CITY OF ALBUQUERQUE

April 29, 2022

Re: Chase Bank - ATM
5201 Ouray Rd. NW
Traffic Circulation Layout
Architect's Stamp 04-20-22 (H11-D059E)

Based upon the information provided in your submittal received 04-22-22, the above referenced plan cannot be approved for Building Permit until the following comments are addressed:

ENLARGED PROPOSED SITE PLAN

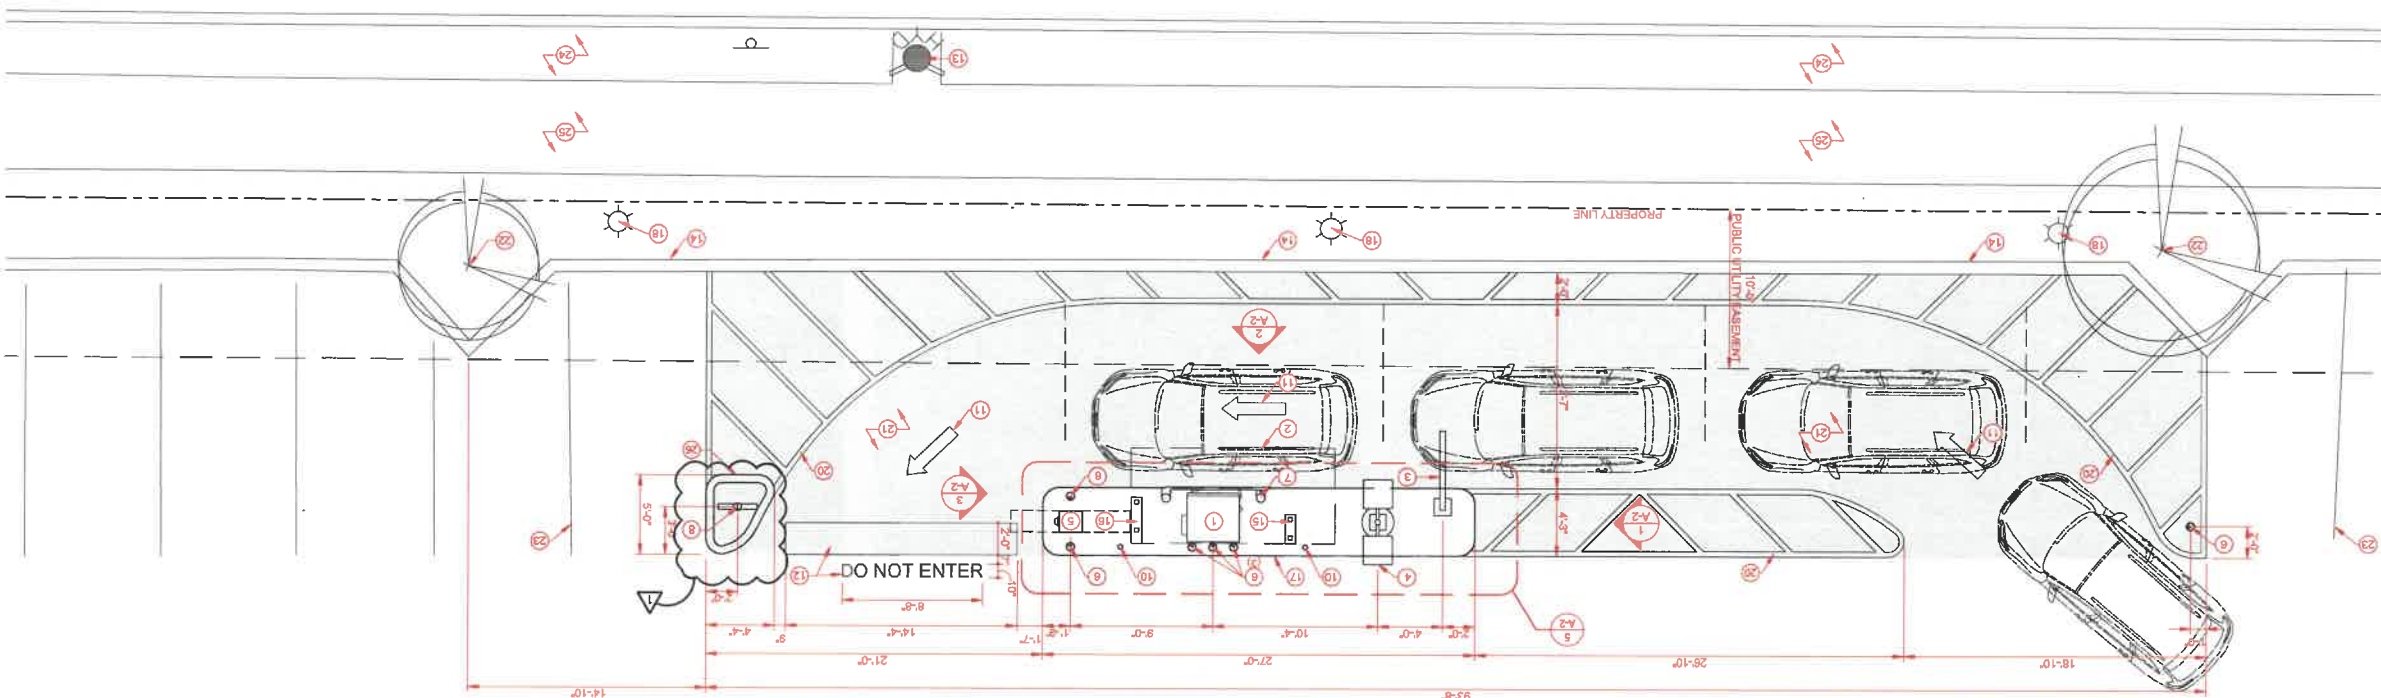
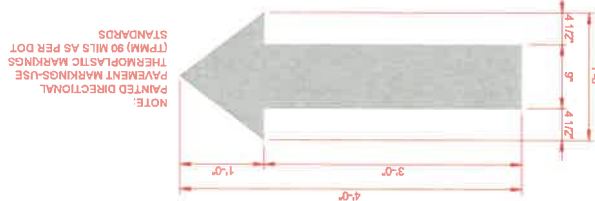
1. Please show a vicinity map showing the location of the development in relation to streets and well known landmarks.
2. Provide Lease agreement with property owner.

3. Due to proposing ATM at some of parking stalls, Provide parking calculation showing the rest of the parking spaces still meet the requirement for this property.

4. The minimum drive through lane width is 12 feet with a 25 foot minimum radius (inside edge) for all turns. (A 15 foot radius can be used with an increase in lane width to 14 feet). Please dimension all lane widths and radii.

5. Provide 20 ft long space for each car in the drive-through.
6. Last car in the drive-through is blocking the parking space adjacent to the ATM drive-through. Please address this concern.

7. Provide the drive aisle width from the ATM to the north landscape island.
8. Please specify the City Standard Drawing Number when applicable.
9. Keynote 8: Provide details for "STOP" "DO NOT ENTER" sign.
